Engineers Comments Regarding Surface Water Drainage

Application Reference:	BN/43/26/DOC	Reviewer Reference:	ADC/EXT4
Planning Officer:	Amber Willard	Date of Review:	08/05/2026
Site Name:	Eastmere Stables Eastergate Lane Eastergate PO20 3SJ		
Application Description:	Approval of details reserved by condition under BN/99/22/OUT (Appeal Ref: APP/C3810/W/22/3312864) relating to condition 9- Surface Water Drainage.		
Assessment Number:	1 of 2

Response	Condition 9: No objection
-----------------	----------------------------------

**ACO CHANNEL DRAIN DETAIL**

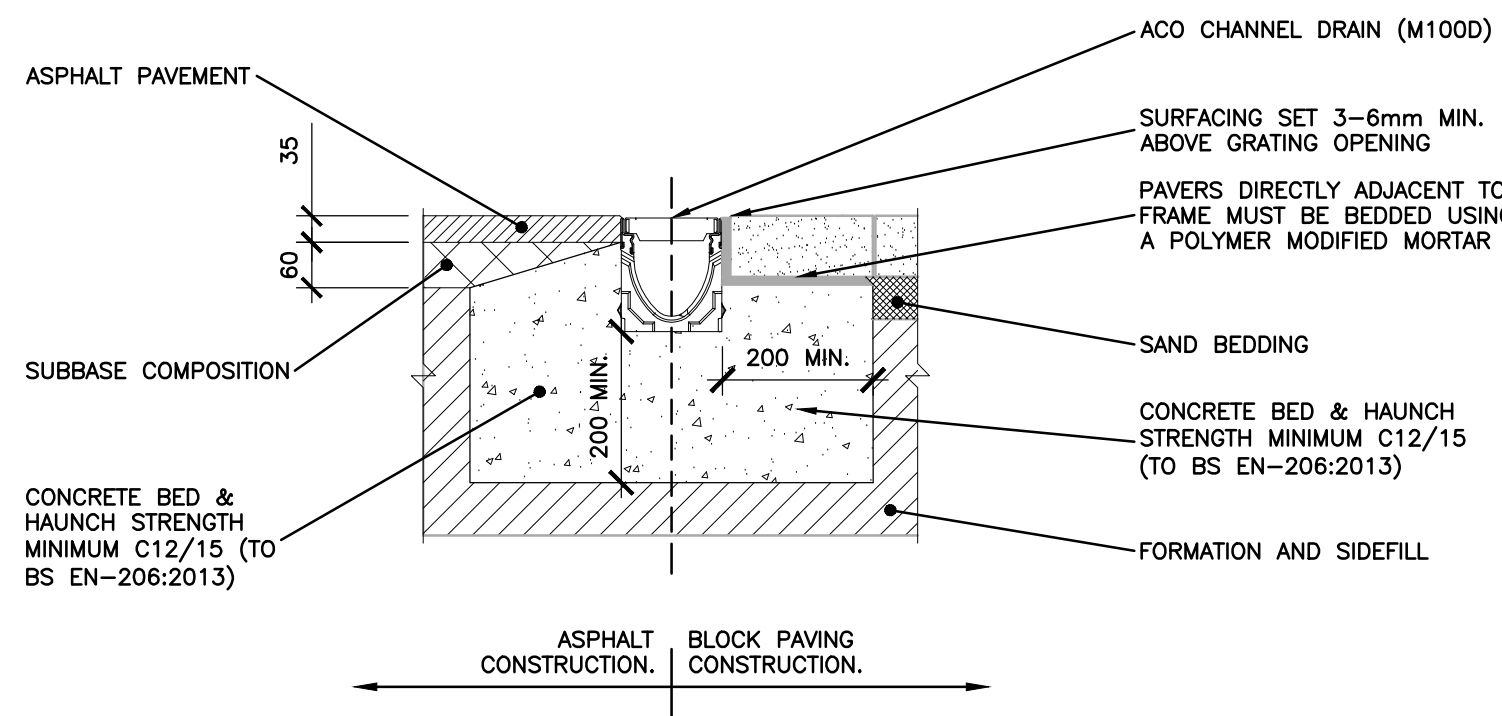
10.	Specify all levels associated with the channel drain at the site entrance (ie. Outlet invert, manhole cover and invert, diffuser unit invert. Pipe diameters and gradients also to be shown	Now added to drawing	Thank you item now closed Designer Response 26/03/2026 Noted

Scale	Paper size	Date	Drawn by	Checked by	Status
1:250	A1	FEB 2025	JH	CH	S0
Name					
Project code	Original	Functional	Spatial	Form	Number
AAL436-AAL-SF-XX-DR-C-5101					c05

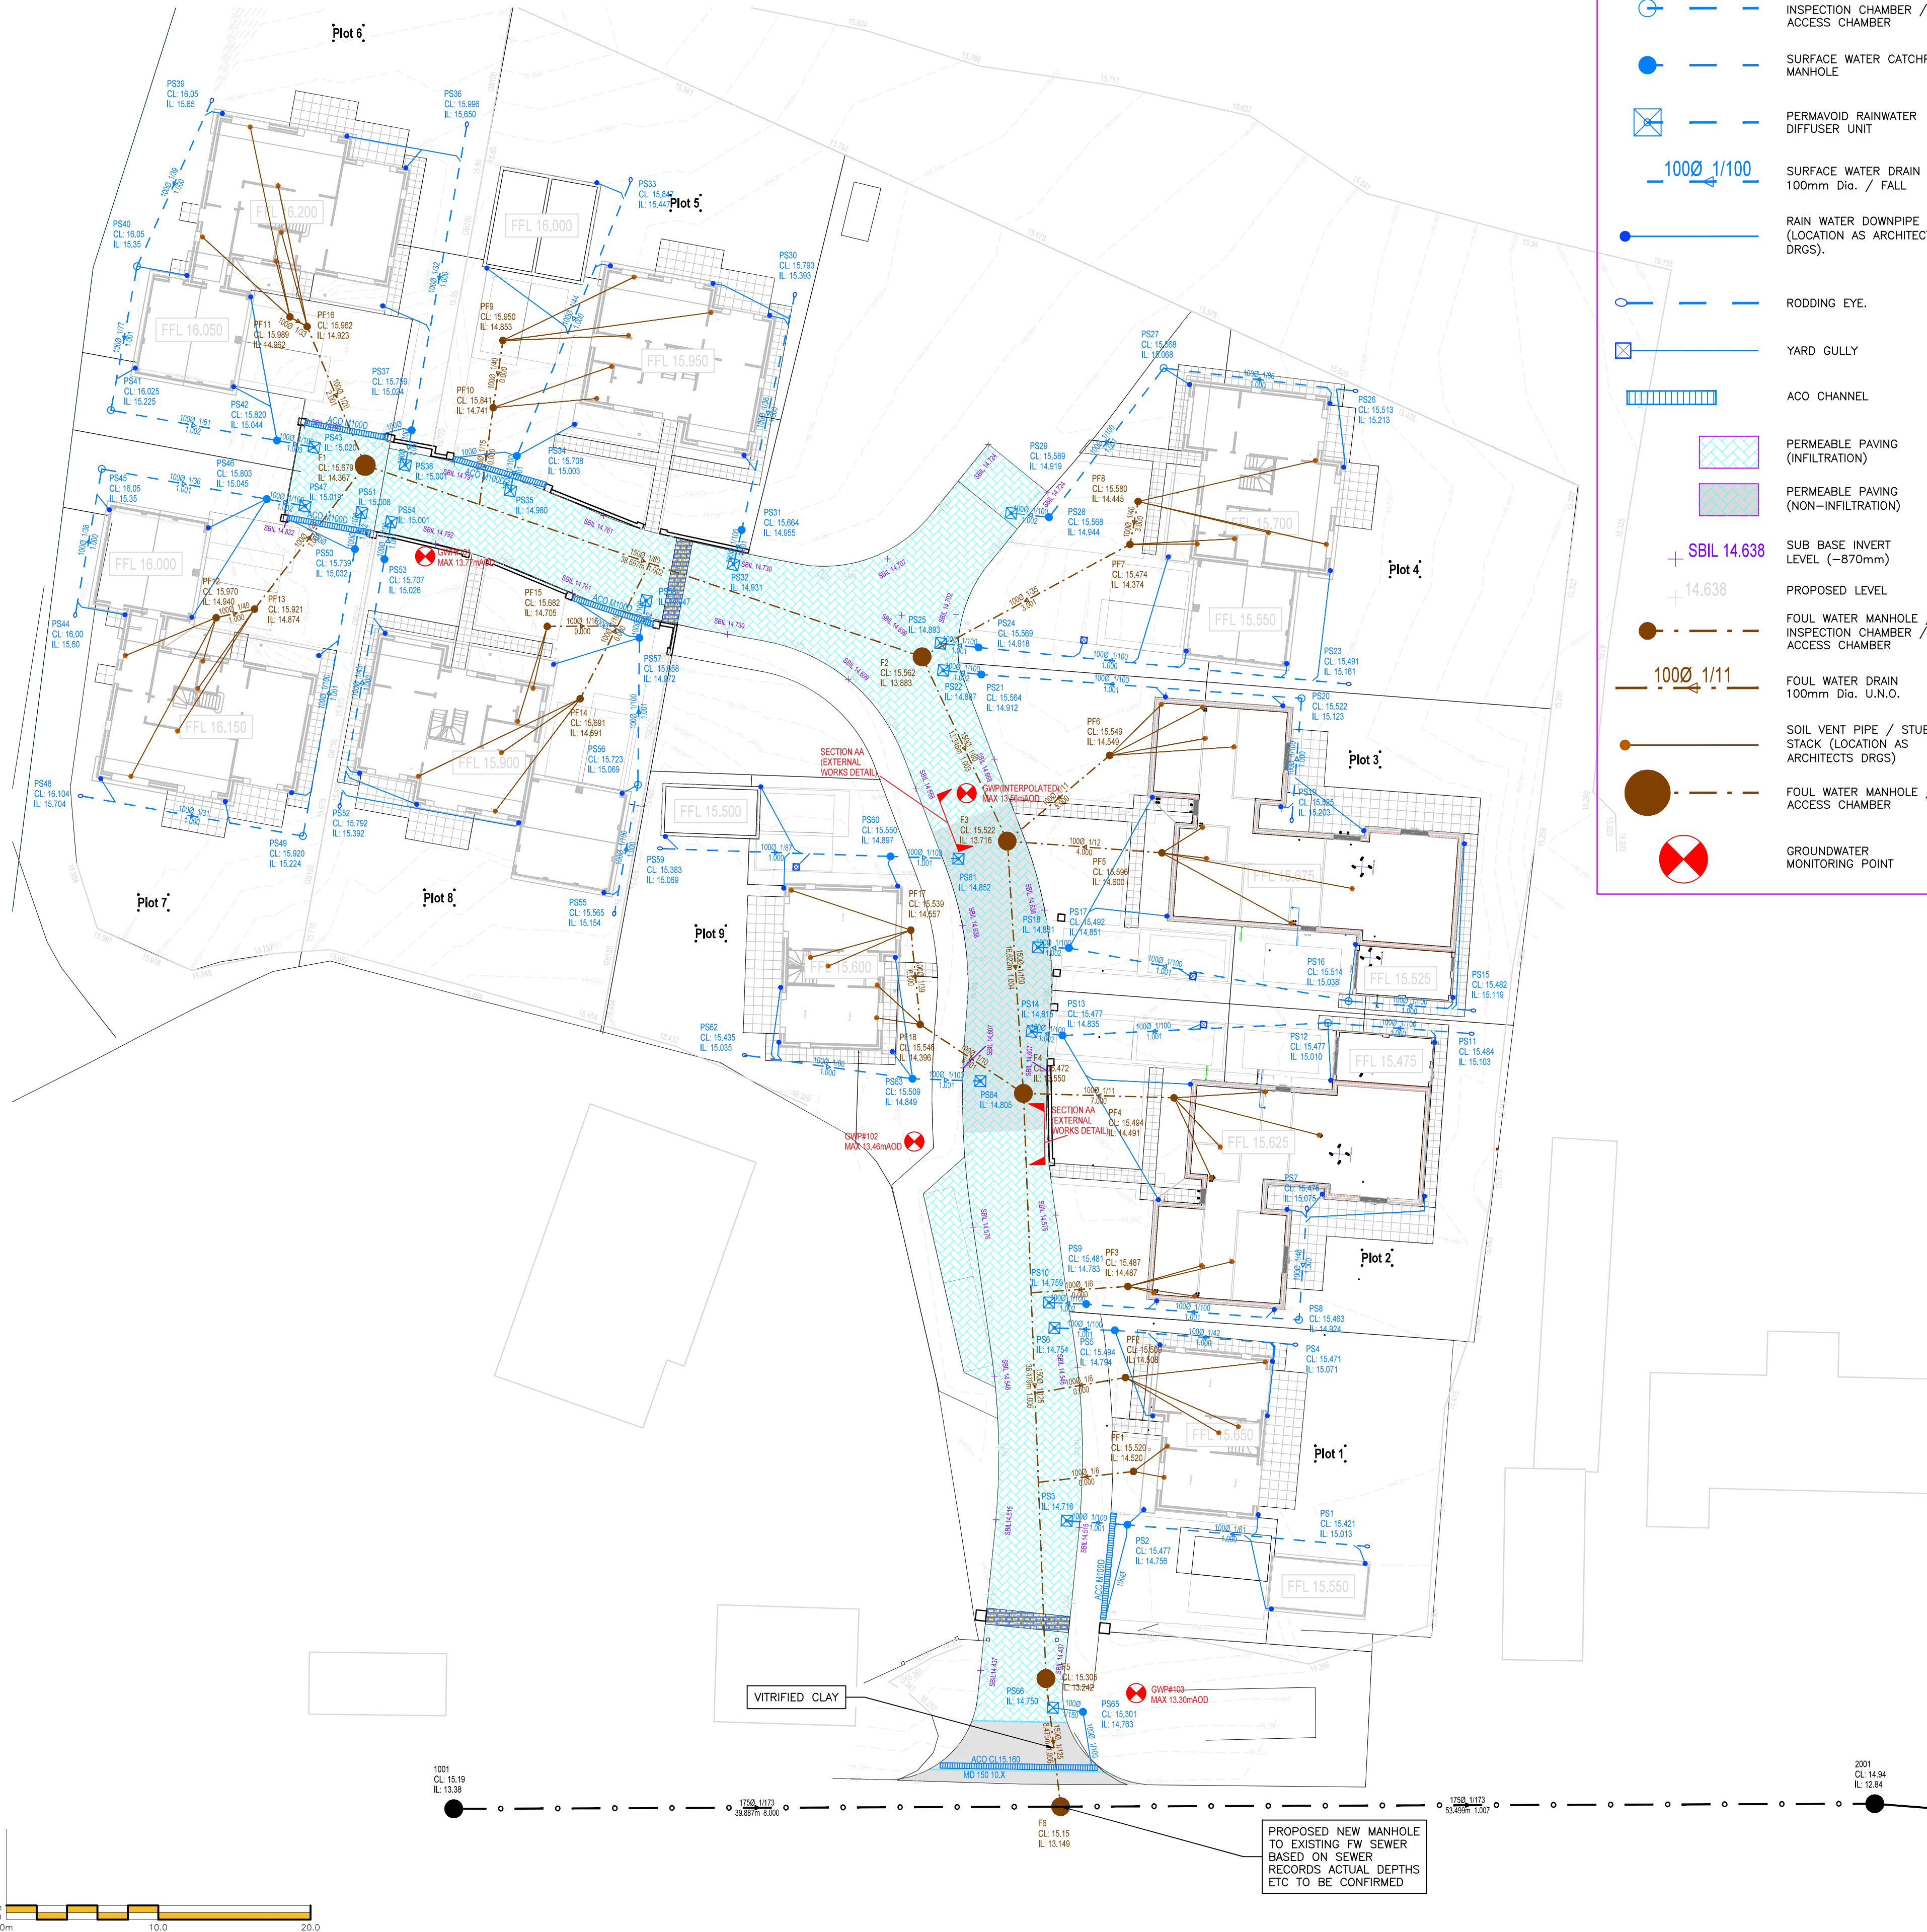
The construction details only refer to verges and carriageways. Please adjust to include areas around buildings/in gardens.				
8.	Indicate permeable paving formation levels on drainage layout plan, for the entire length of permeable road.	This has now been added via 'SBIL' level annotation.	Thank you item now closed Designer Response 26/03/2026 Noted

9.	Catchpits are required immediately upstream of all diffuser units.	Missing catchpits added to drawing and table	Thank you item now closed Designer Response 26/03/2026 Noted

11.	All pipes not connecting to manholes to be connected via oblique 45 degree junctions. Please specify.	Pipes and connection where needed now show oblique connection	Thank you item now closed Designer Response 26/03/2026 Noted

12.	No pipes to connect against the direction of flow, examples; Connection to manhole north east corner of plot 9 & north side of plot 3.	Pipes updated to show oblique connections to remove apparent against flow connection	Thank you item now closed Designer Response 26/03/2026 Noted
